Subject: 2020 93308 Lidl - lack of details
Date: 03 December 2020 18:02:45

Former Spotted Cow

Site Plan - 1814-P400 Rev AD by HTC Architects

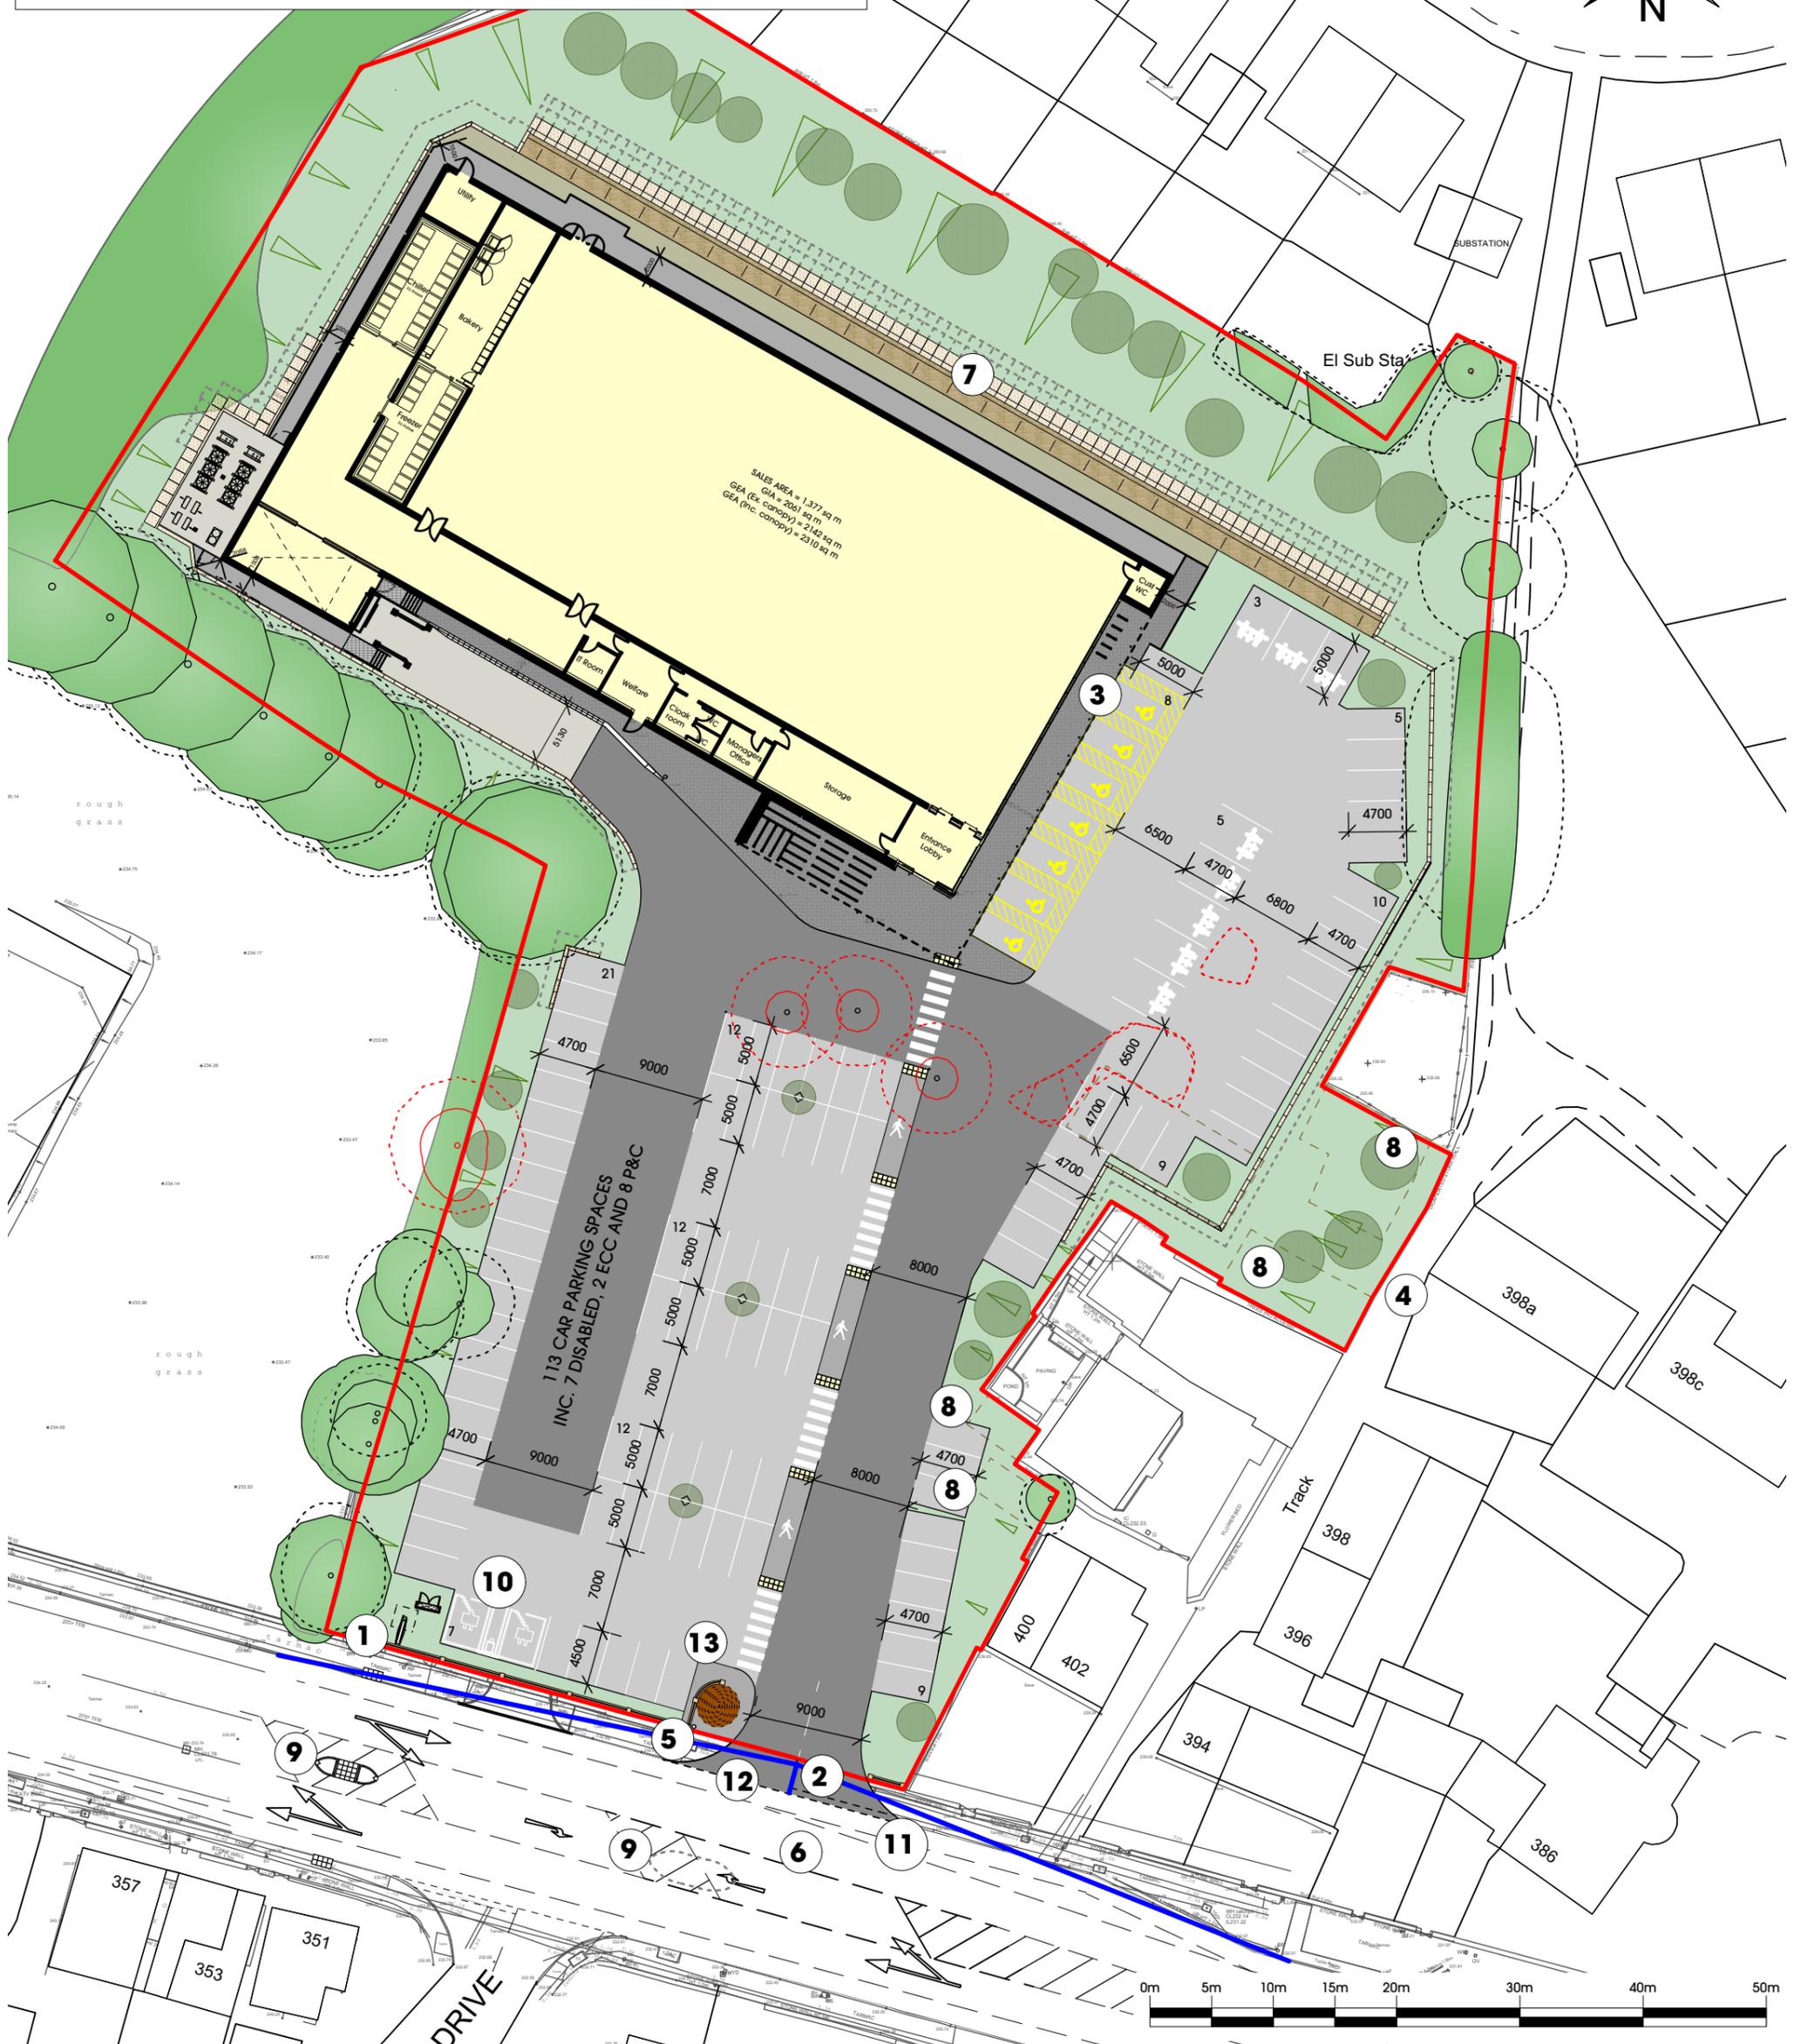
With regards to this application, the area around the boundary adjacent to the public footpath does not appear to have been amended. The public footpath is not included in the proposals, and we have made comments on this previously.

Public footpath Huddersfield has a recorded width of 1.5 m and runs along the eastern boundary. The proposal does not indicate how the path will be dealt with. The block plan indicates that the existing fence/railings will be retained. However, the proposed retaining wall indicates a 8m or 9m retaining wall with open boarded timber fencing to rear or the wall is shown on the retaining wall elevations.

Please clarify how the design and retaining wall will be incorporated in with the footpath.
